HIGHWAYS DEVELOPMENT CONTROL  
APPLICATION CONSULTATION RESPONSE

PLANNING CASE OFFICER	Elaine Ward
HIGHWAYS OFFICER	Wayne Lake
PLANNING APPLICATION REF.	2024/1041
LOCATION	Land Bmbc Asset Id E01874, Woodbourn Way, Hoyland, Barnsley, S74 0QA
DESCRIPTION	Details of condition 7 (Construction Method Statement) of planning permission 2021/0479 (Erection of 3no industrial/warehouse units use classes B2 and B8 and E(g)(ii) and E(g)(iii) totalling 11,585 sqm floorspace and associated works including provision of access, parking and landscaping (Amended Plans))

28/01/2025

PROPOSED SITE PLAN/ LOGISTICS

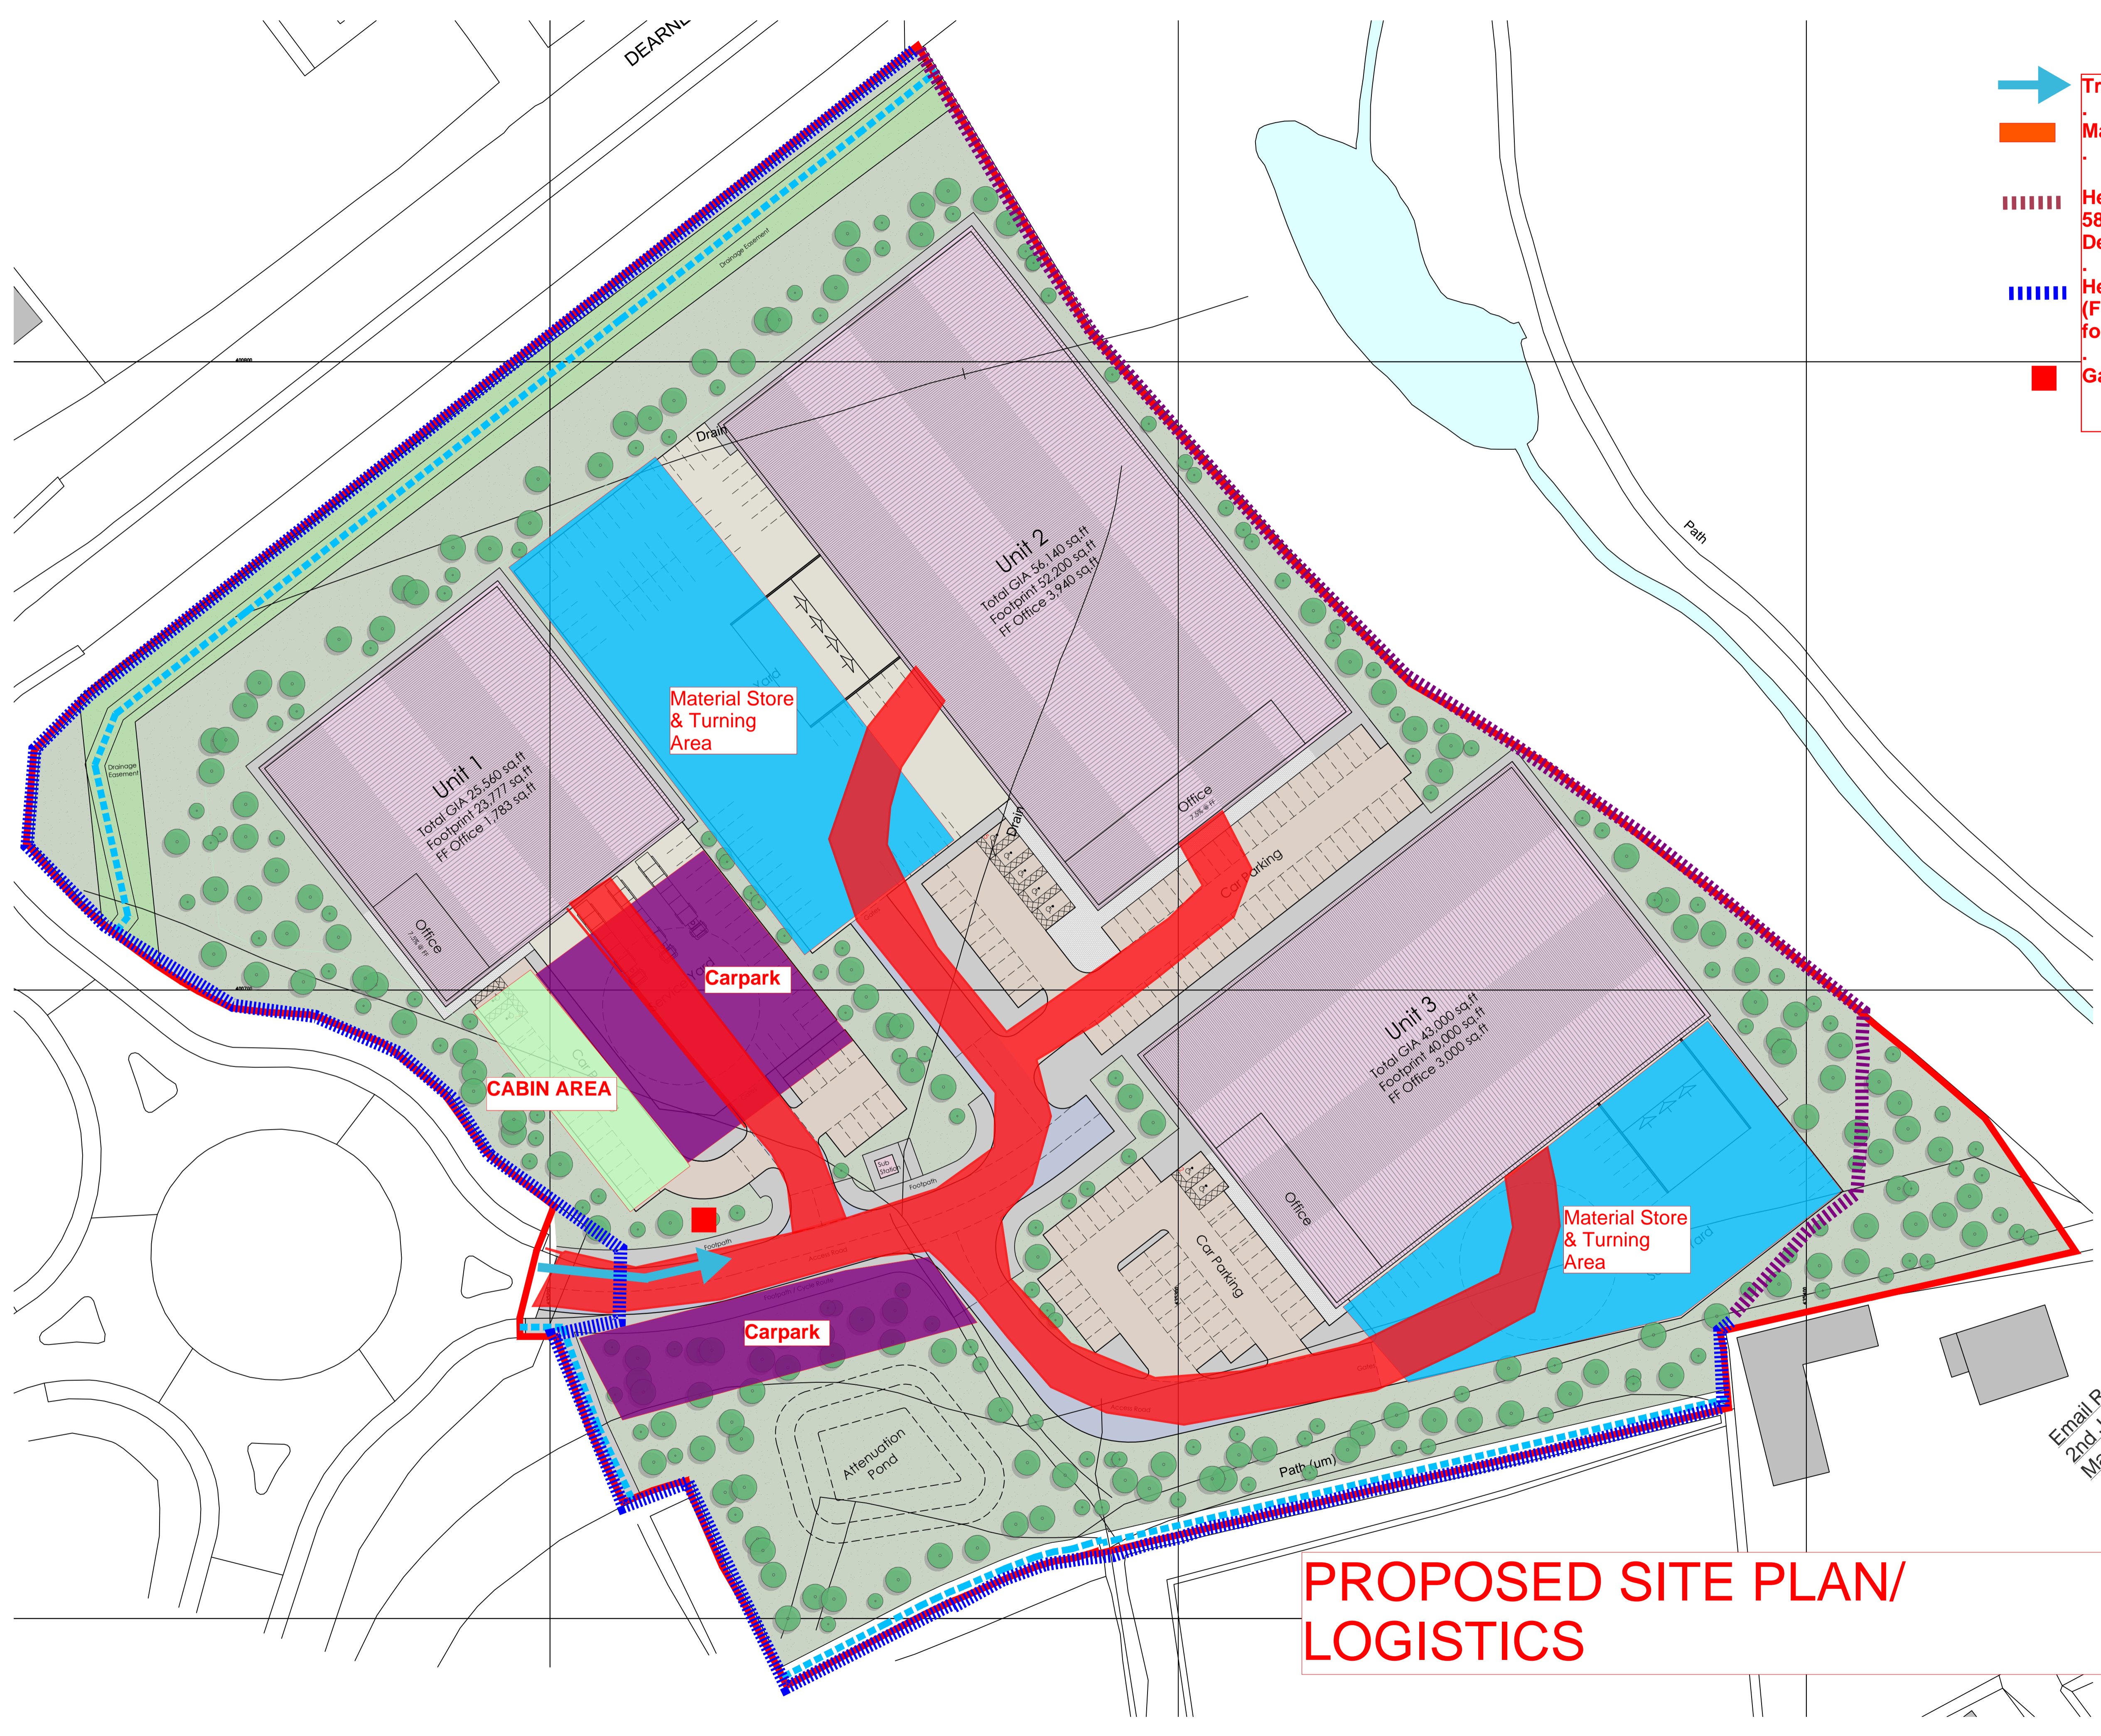
*The site will be accessed via the existing roundabout entry/exit on Sheffield Road. All construction access to the site will be via this gate and all access across the site will be by internal site Haul Routes as indicated on Site plan / logistics mark up (See Appendix A). The gates into the site from the estate roundabout will be set back to allow a vehicle to be waiting to enter the site area without blocking the roundabout.*

However, whilst the plan in Appendix A shows the Heras fencing set back some 24 – 30 metres from the circulatory carriageway of the Fitzwilliam roundabout, and 2(i) states that *A strict delivery procedure will be implemented to ensure that the roads surrounding the site are not overrun with delivery and site vehicles* No details are presented within the plan as to how deliveries to site will be regulated to prevent stacking of vehicles at the site entrance. Please provide further detail in respect of this.
